Your ref:
Our ref: 24/00576/F
Please ask for: Miss Joanne Wren
Direct dial: 01553 616233
E-mail: borough.planning@west-norfolk.gov.uk

Details: **Change of use from vacant butchers shop (class E) to 1-bedroom dwellinghouse (C3) and replace the existing asbestos roof with red tiles at (Methwold Old Butchers Shop Old Cottage) 25B High Street Methwold Thetford Norfolk**

I have received a planning application as detailed above but cannot process it until I receive some more information:

Fig.1 – Site Location and Block Plans

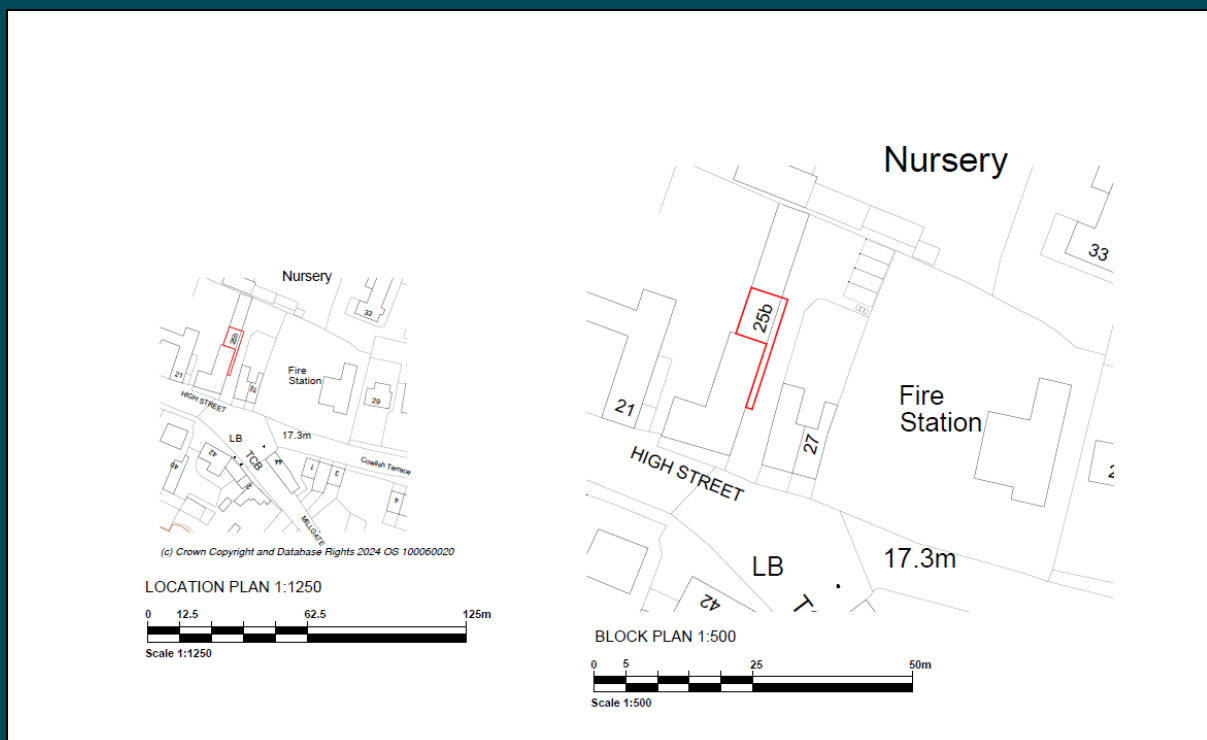
5. Please extend the red line on your location and block plan, this should include access to the highway.
